From: Amanda Scholes on behalf of Planning.Responses
Sent: 02 December 2020 10:48
To: Planning Scanning
Subject: FW: Reserved matters application A/109/20/RES – Land South of Water Lane, Angmering.

Please upload onto Ocella the email below which is a consultation response from the **ADC Drainage Engineers** withdrawing their holding objection to reserved matters application **A/109/20/RES** relating to Land South of Water Lane, Angmering.

Subject: Re: Reserved matters application A/109/20/RES – Land South of Water Lane, Angmering.

Title
LONG SECTIONS
SHEET 2

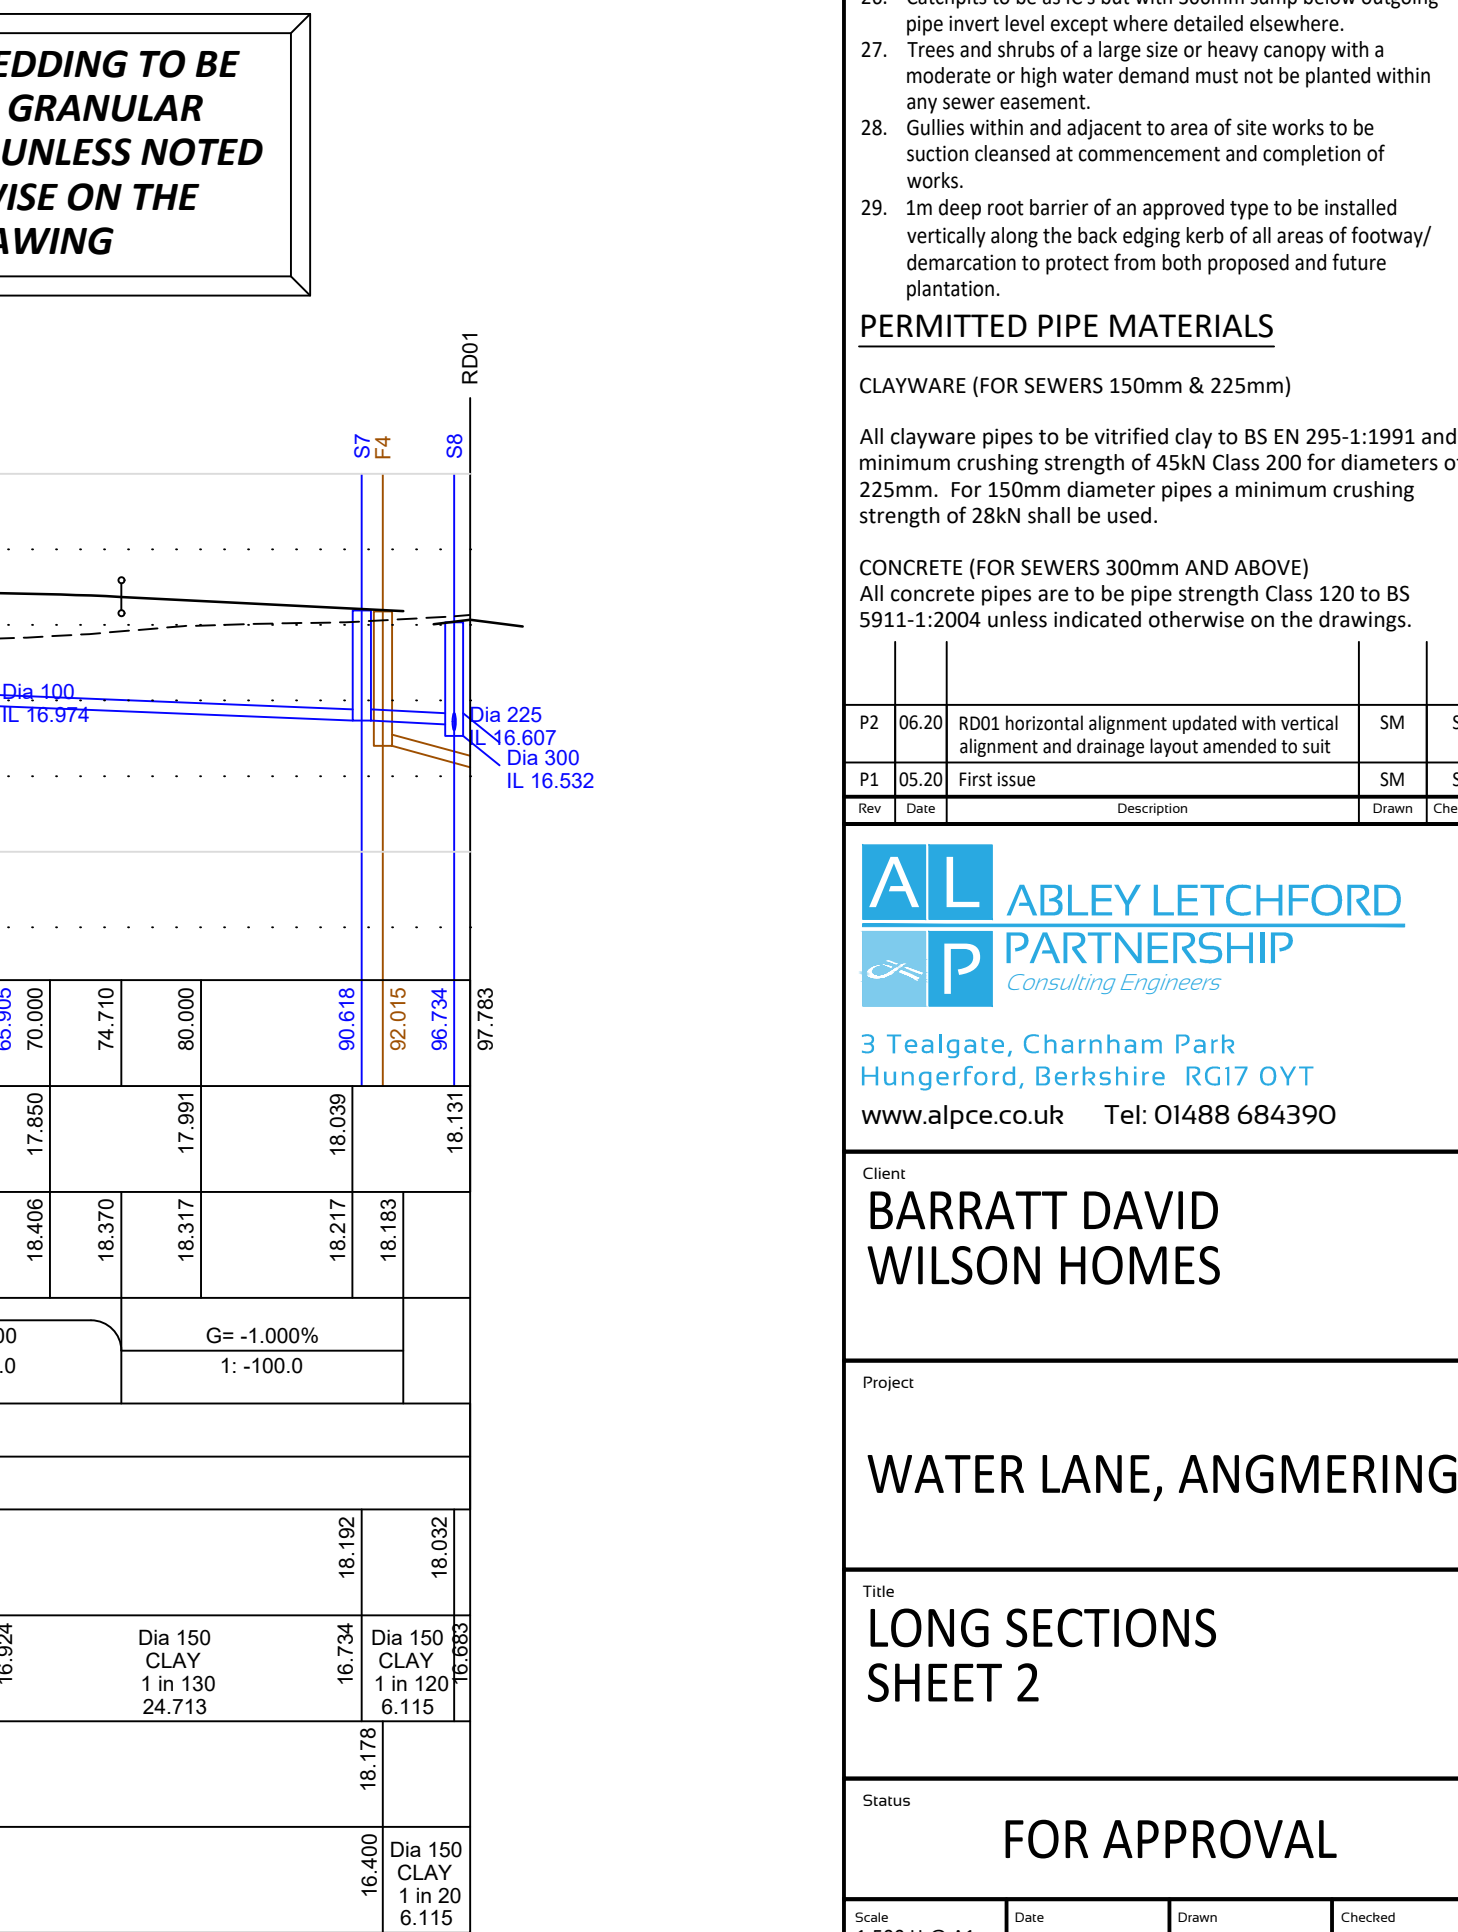
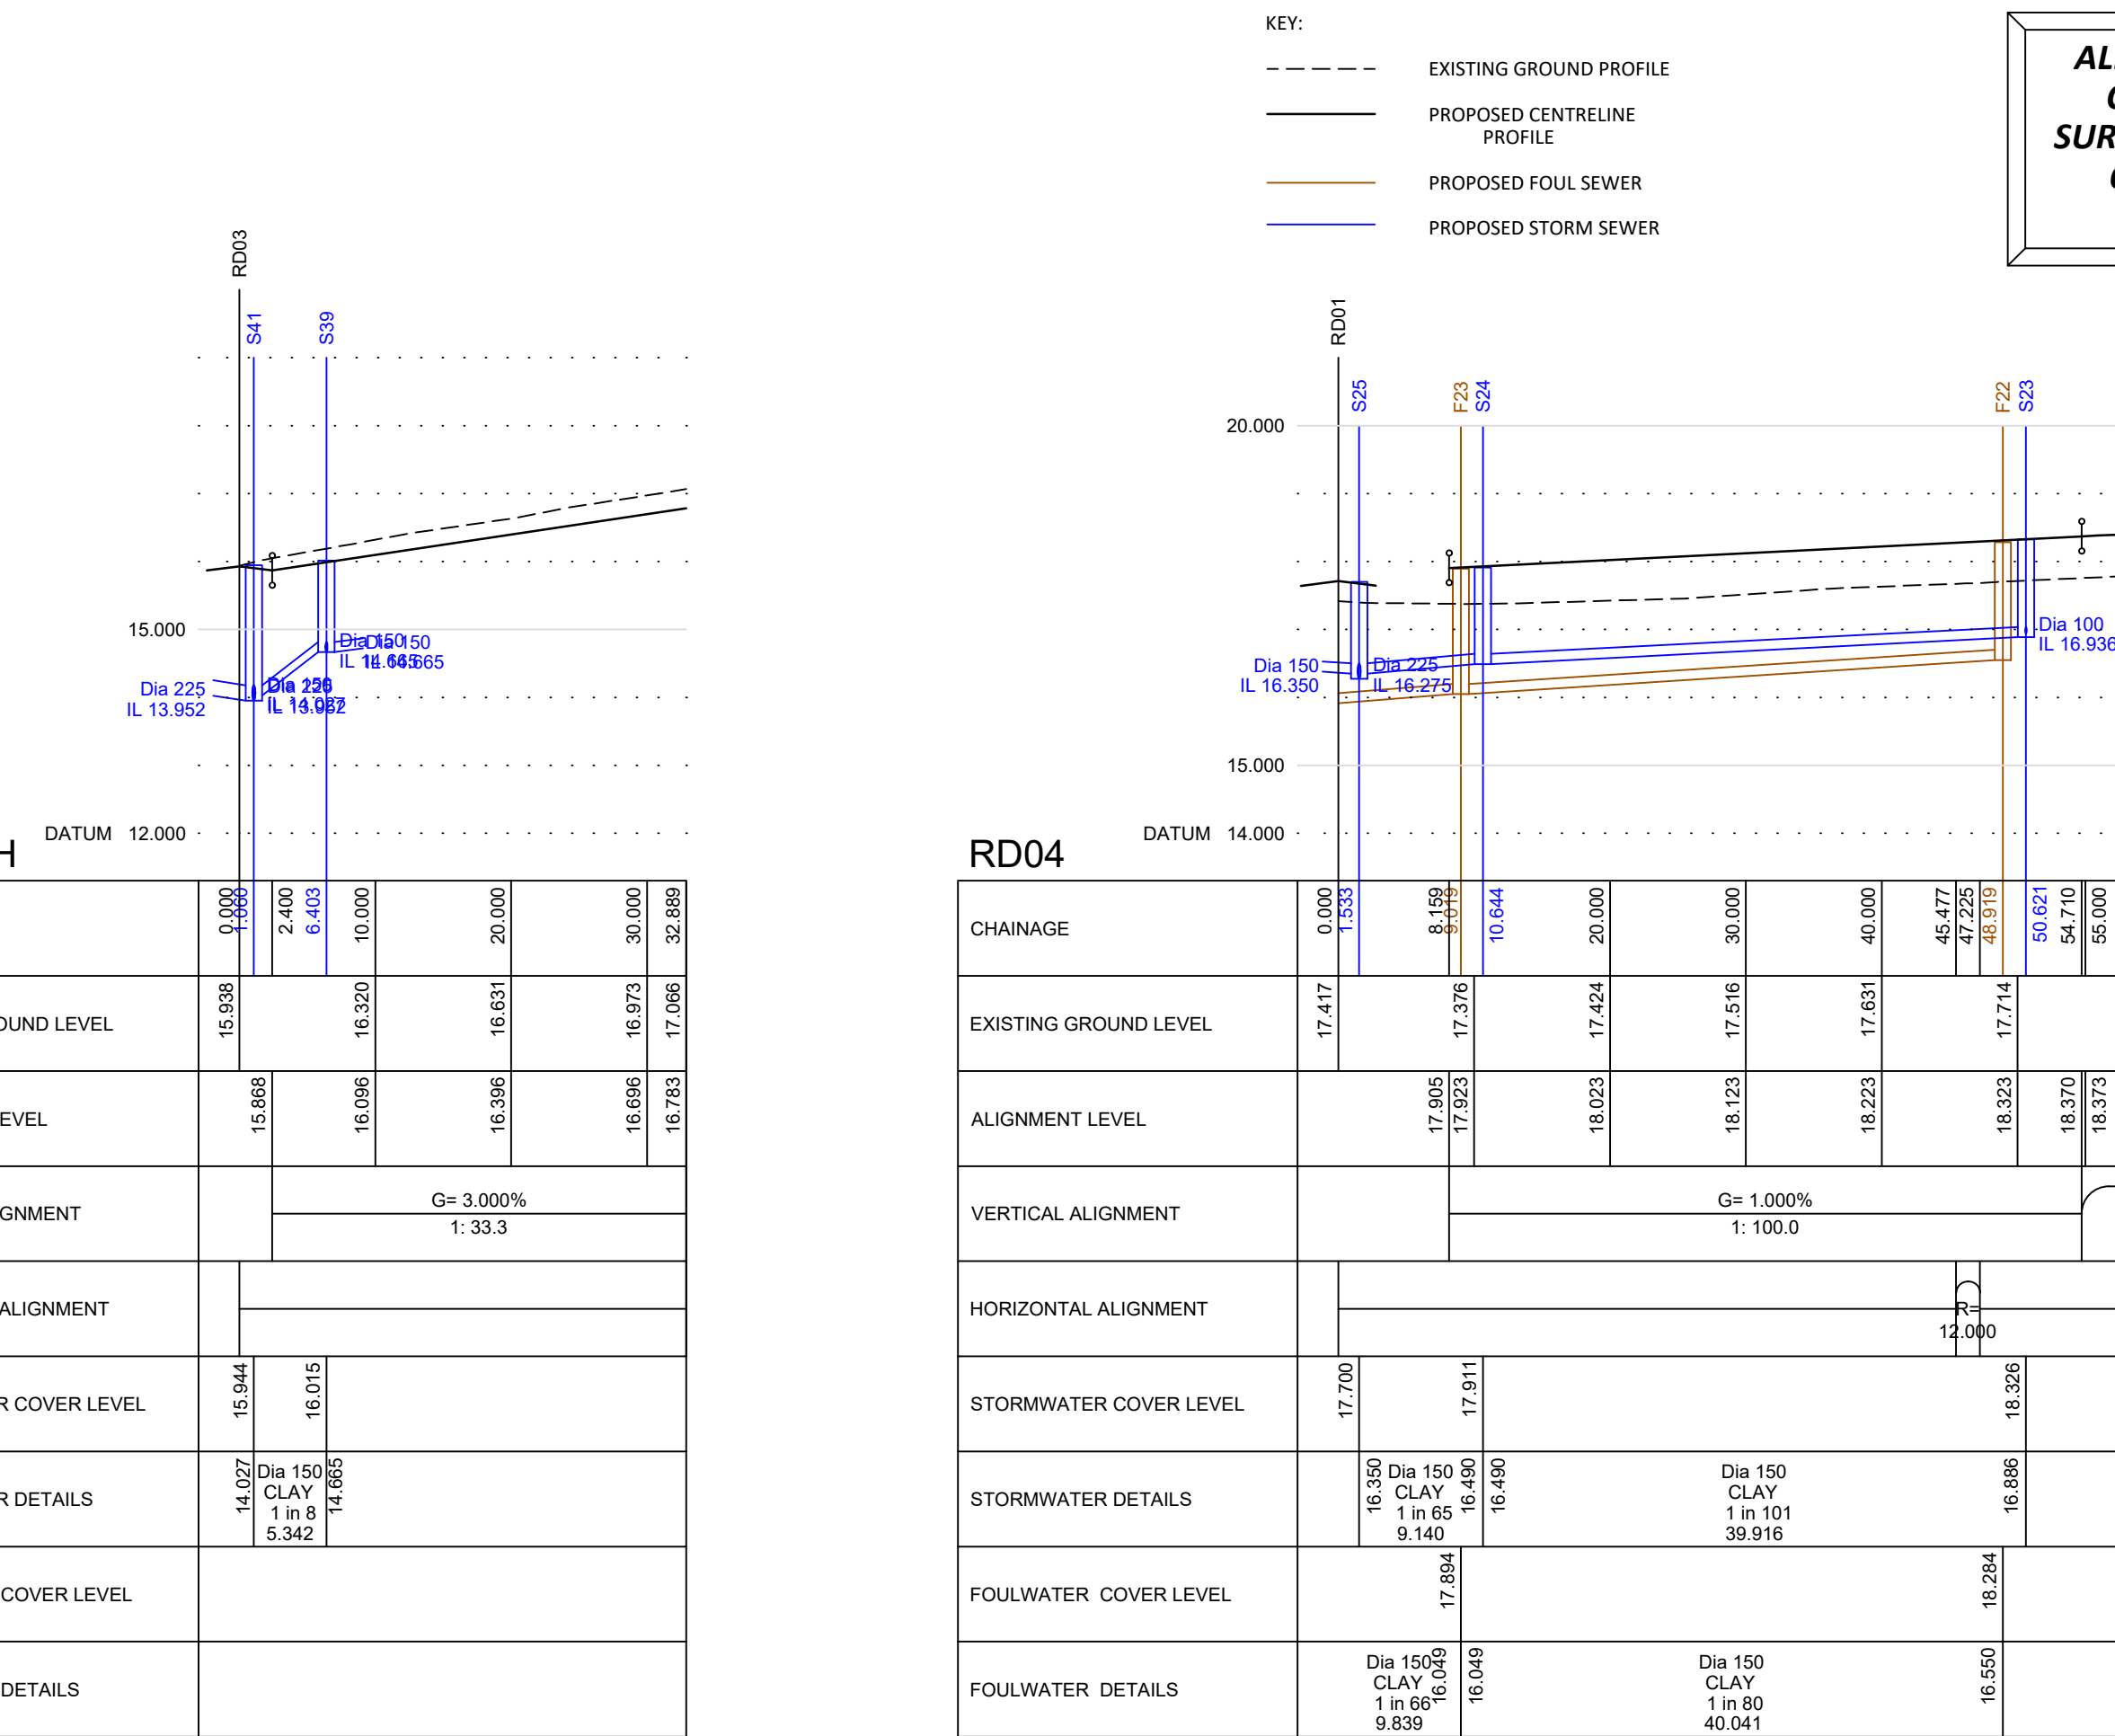
5. We still are not satisfied that water will not flood off site or flood proposed dwellings. Large flood volumes are observed within results. S1.007, with upstream manhole of S25 shows water levels of 13.687, which is greater than the cover and gully level. There are two manholes in the northern network with reference S25, and a layout with pipe numbers has not been provided, making review more difficult and time consuming than it should be. Highway gradients indicate that the access falls to water lane. Without an mdx file and better layout drawings which show cover levels, invert levels, surface levels and FFLs we have serious concerns about the degree of flooding predicted. Insufficient evidence has been submitted to allay these concerns. Please see below. Firstly we apologise as there is an obvious mistake in that the first S25 should be S23, to follow the obvious manhole numbering, which follows numerical sequence. However, as stated in the technical note "The cover level of S25 (upstream of 1.008) is 13.561m AOD with the gullies at 13.380m AOD. The water level in MH S25, in the 1 in 100 year storm event plus 40% climate change, is 13.214m. Therefore, even in this extreme storm event water does not spill from the gullies downstream of S25." There are also no "large" volumes of flood water on any of the northern print outs, even in the tested Urban Creep design which as stated is highly sensitivity tested, with the only flooding in that area being 0.106m³, basically a basin full. Please can we clarify. The drainage system should only be designed to cater for the 1:30 year storm with any storms in excess of this being allowed to flood and controlled within the site boundaries by either keeping it within highways, and/or directing it to greenspaces or ditches/watercourses. We have provided 1:100 year storm events with 40% climate change included with minimal flooding throughout the development even within the sensitivity tested overly designed Urban Creep scenario. The results show no flood risk to properties on or off site. *To confirm water from events exceeding the 1 in 30 year event must not exit your site without being attenuated, to allow spill into watercourses would increase flood risk off site. Policy requirements are clear that any exceedance water must be safely contained in site, the information you have provided to date has not demonstrated this. Some nodes in the site do show flooding in excess of 5m³ with some near to 15m³.*

Further to the below and Michael's email please find attached a further technical note following your comments. We have also included a link below to the amended drainage and areas drawings, and attached the full drainage print outs as well as an areas table.
